**KIRKLEES METROPOLITAN COUNCIL
INVESTMENT & REGENERATION SERVICE**

**DELEGATED DECISION TO DETERMINE APPLICATIONS FOR
CONSENT, AGREEMENT OR APPROVAL REQUIRED BY CONDITION**

Reference No:	2023/44/92061/E
Site Address:	119, Huddersfield Road, Mirfield, WF14 9DA
Description:	Discharge of conditions 6 (right-turn lane), 8 (Construction Management Plan), 10 (electric vehicle charging), 11 (Phase II report), 16 (Air Quality Impact Assessment), 18 (temporary drainage), 20 (surface water drainage), 22 (hardstanding drainage) and 27 (external lighting) of previous outline permission 2019/92221 for demolition of existing buildings and erection of Class E retail unit, access, car parking, servicing, landscaping and associated works (all matters reserved other than access)
Recommending Officer:	Nick Hirst

DECISION – Discharge of Conditions – Split Decision

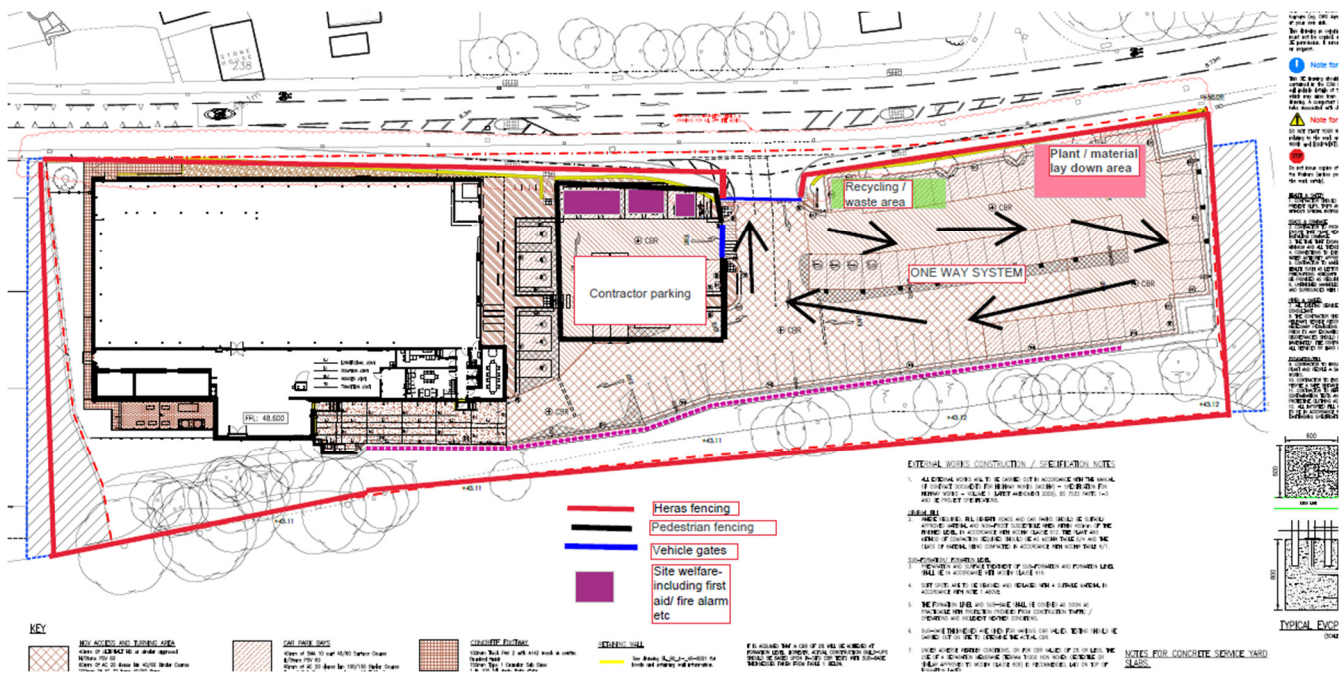
K.C. Highways have stated that insufficient details on cleaning the highway of mud / debris have been provided and that the times of access to the site should be amended to not conflict with peak traffic (0800 – 0900 and 1700 – 1800). Officers share these concerns and do not consider the information to address all requirements of condition 8.

- No details of 'A scheme to demonstrate how the highway will be kept clear of mud/debris', as required by the condition, have been provided.
- The proposed times of use of the access for construction traffic are 07:00 – 18:00 Monday to Friday, 08:00 – 14:00 on Saturdays, and at no time on Sundays or Bank Holidays. Due to the busy nature of Huddersfield Road (A644) the access hours should exclude the morning (0800 – 0900) and evening peaks (1700 – 1800).

Project:		HUDDERSFIELD ROAD MIRFIELD	
Client:		ALDI STORES LTD	
Drawing:		SECTION 278 WORKS GENERAL ARRANGEMENT	
Drawn By:	TS	DATE:	05/05/2022
Checked:	RC	Scale:	1:250 @ A1
Drawing No:	AMA/40110/D/001	Rev:	1

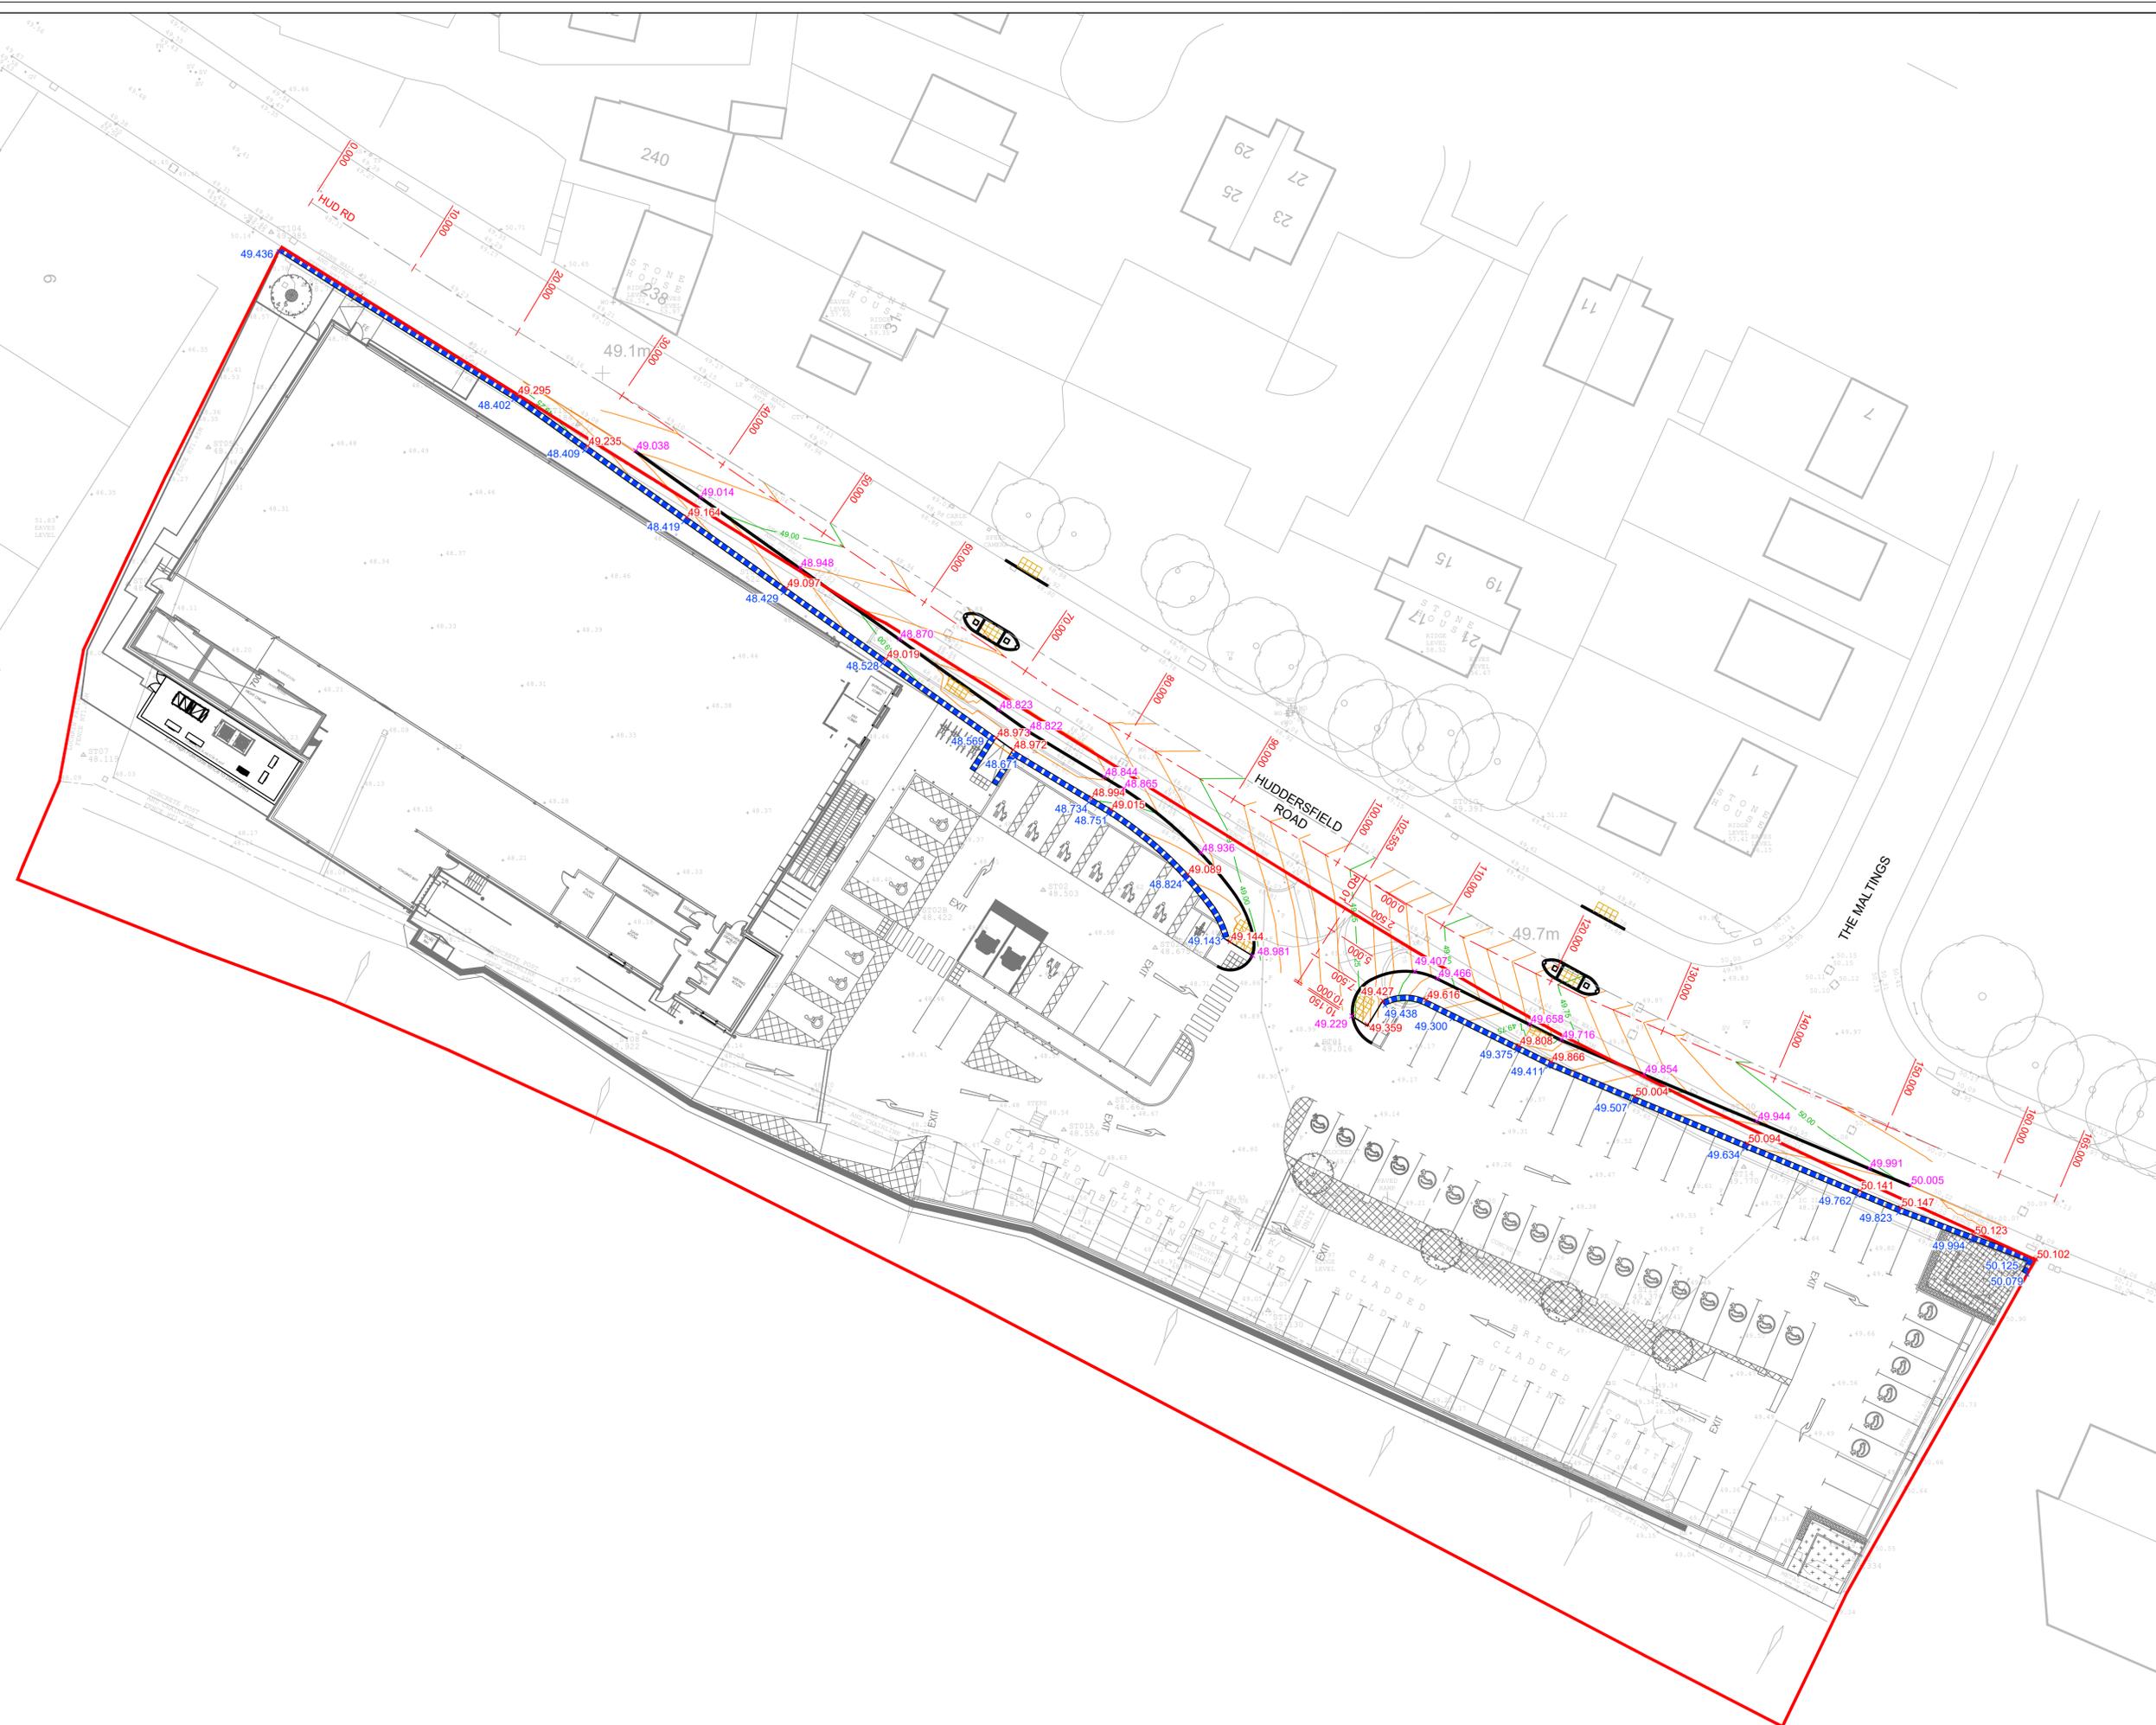
The applicant is in negotiations with K.C. Highways (Section 278 team). An acceptable highway design has not been proposed to date. The applicant's submitted design does not address the requirements to ensure the safe and efficient use of the highway. Until the design is revised to the satisfaction of K.C. Highways, officers are unable to recommend approval.

The submitted details are not accepted. It is understood that negotiations are continuing between your team and K.C. Highways (Section 278 team), with various concerns raised and outstanding. The current proposal would not secure the safe and effective use of the highway. Negotiations should continue to resolve any outstanding matters.
